CITY OF ALBUQUERQUE

PLANNING DEPARTMENT – Development Review Services

December 12, 2016

RE: Star Limo
800 Avenida Caesar Chavez, Albuquerque, NM
Grading and Drainage Plan
Stamp Date 11/16/2016 (File: L15D059) ⁴ AC

GRADING AND DRAINAGE PLAN

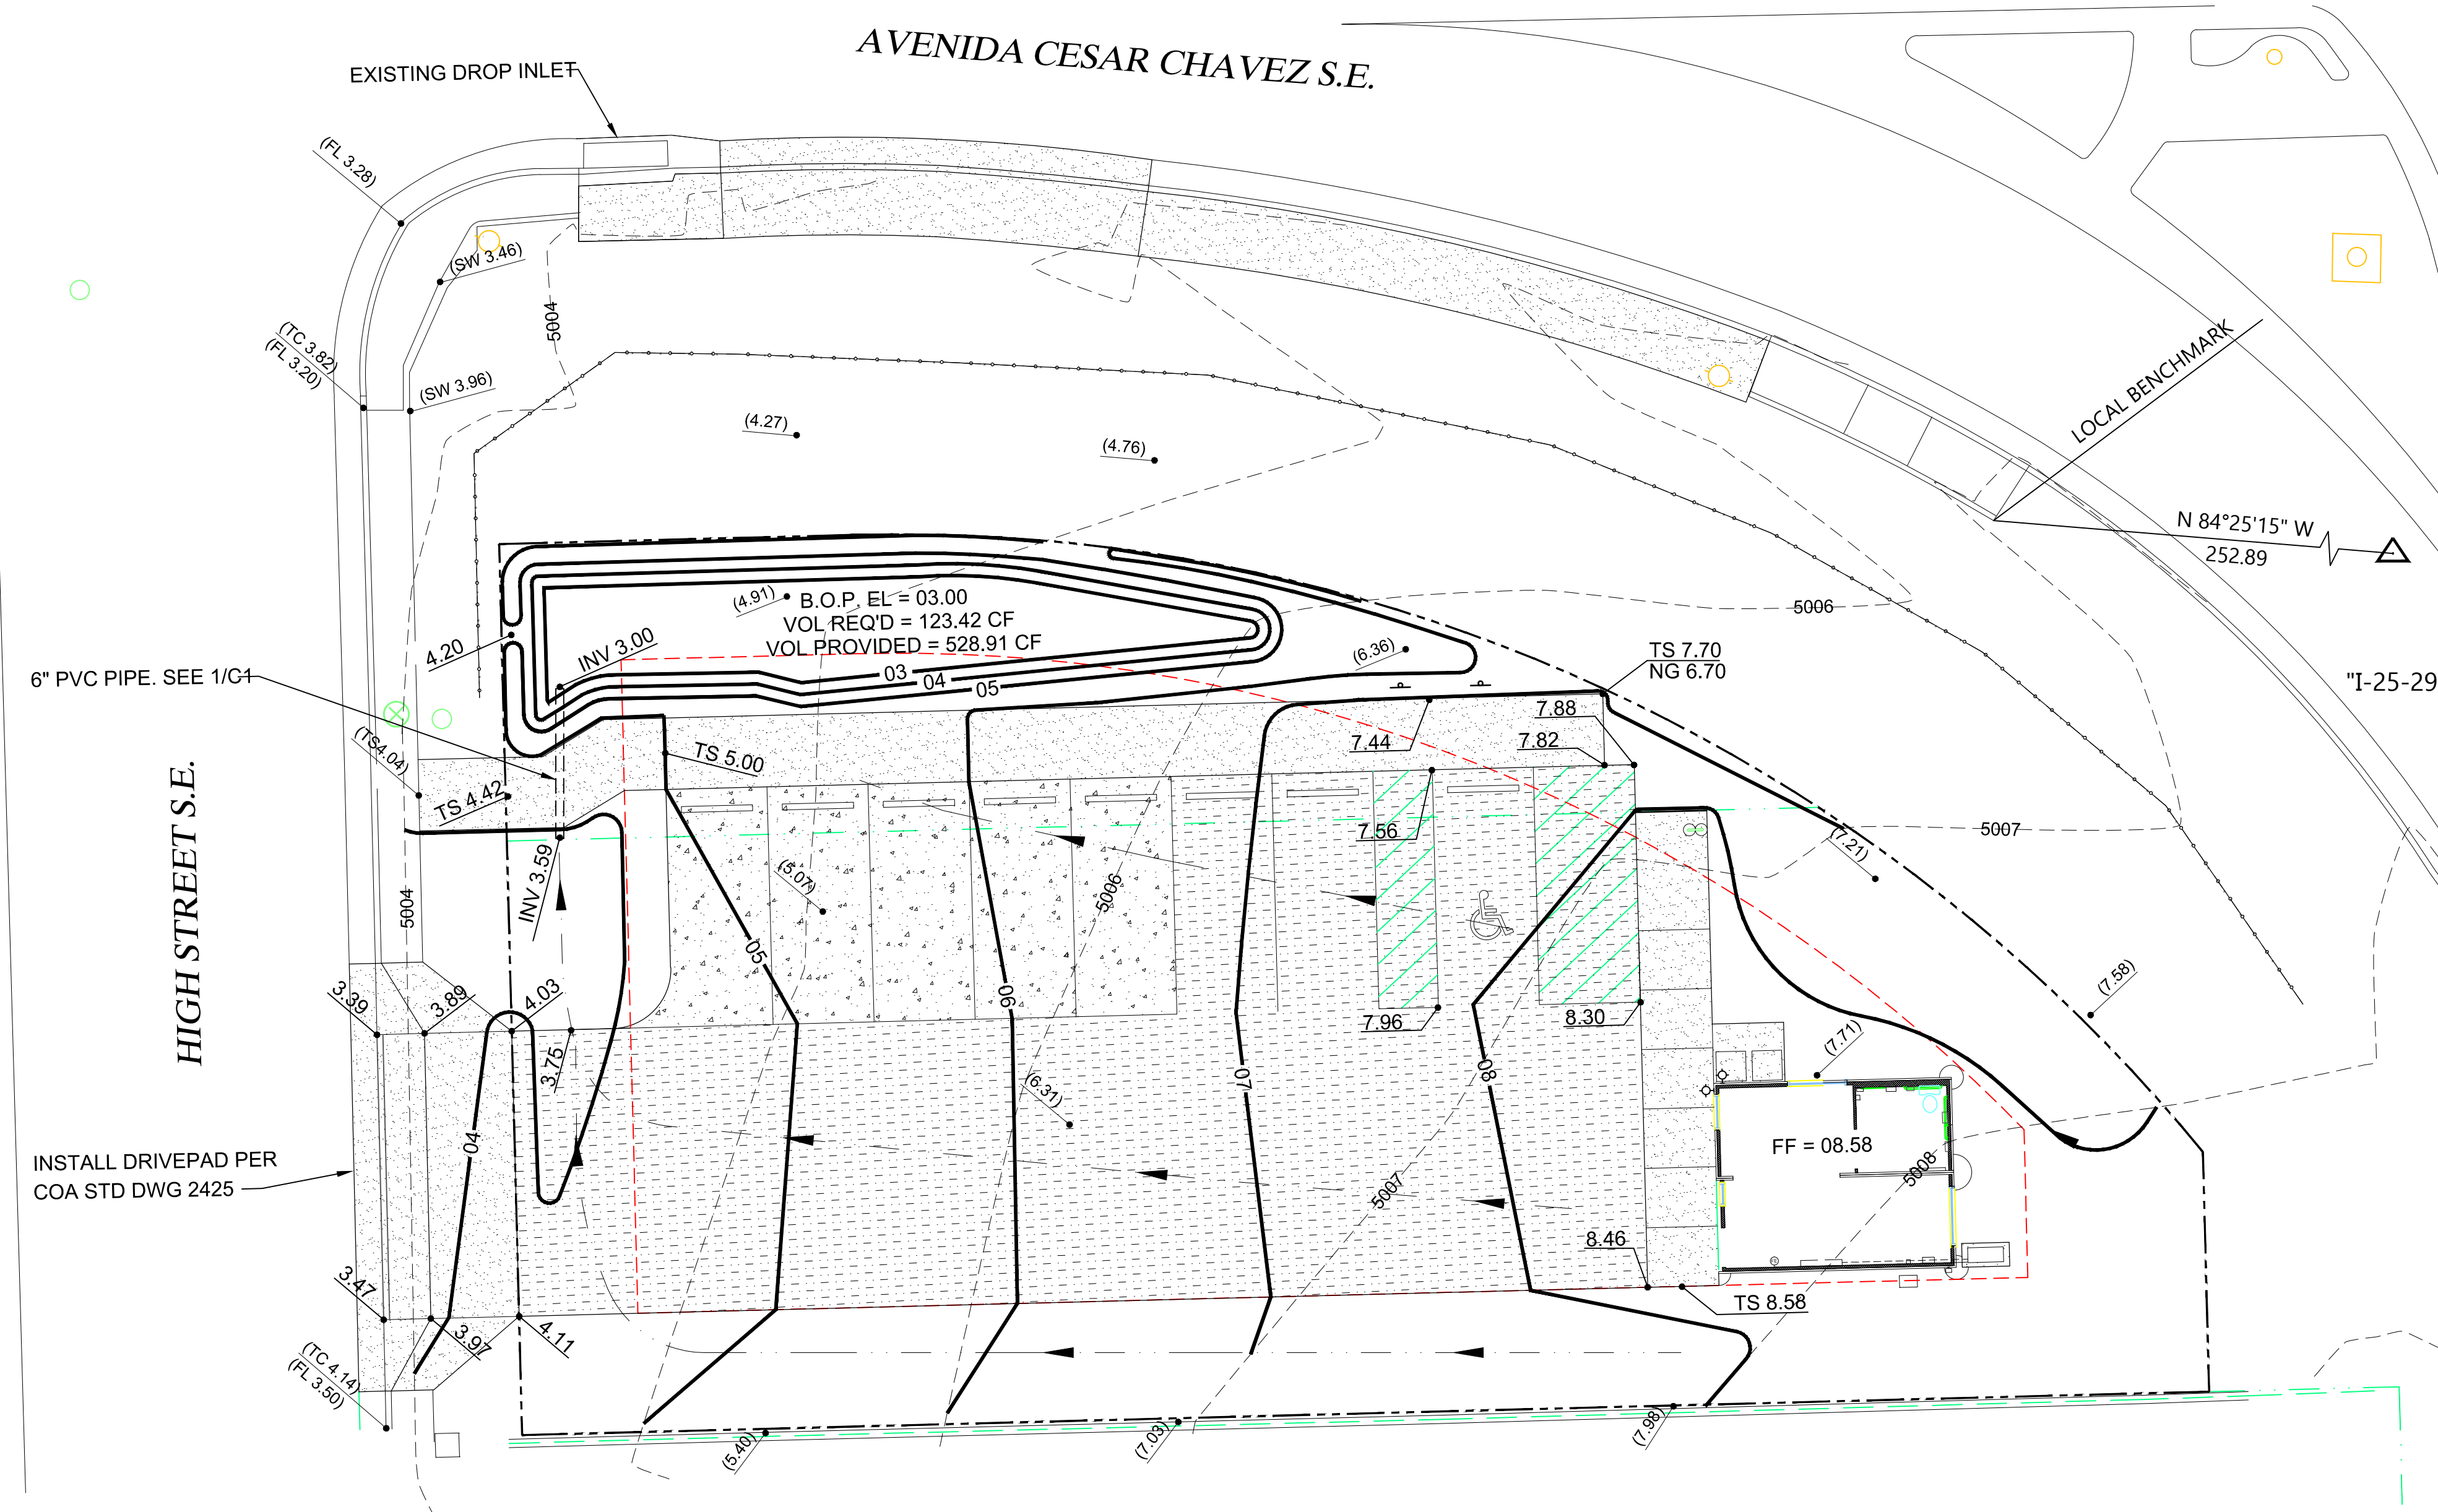
1. Provide existing spot elevations and/or contours to review the proposed grades.
2. Provide calculations for the stormwater quality volume.
3. It appears that a majority of the parking lot drains out the drive entrance rather than into a stormwater quality pond. If this area is impervious it is to drain to a water quality pond prior to discharging to the street.
4. Provide the water service elevation for the stormwater quilted volume.
5. Show Property Lines; does this project impact the NMDOT right of way?
6. Include a legend for the hatch areas.
7. Provide the monument for the benchmark and vertical datum.
8. The culvert plate needs to be extended 1-foot behind the side walk.
9. The narrative states there are three flush water ponds, when there is only one.
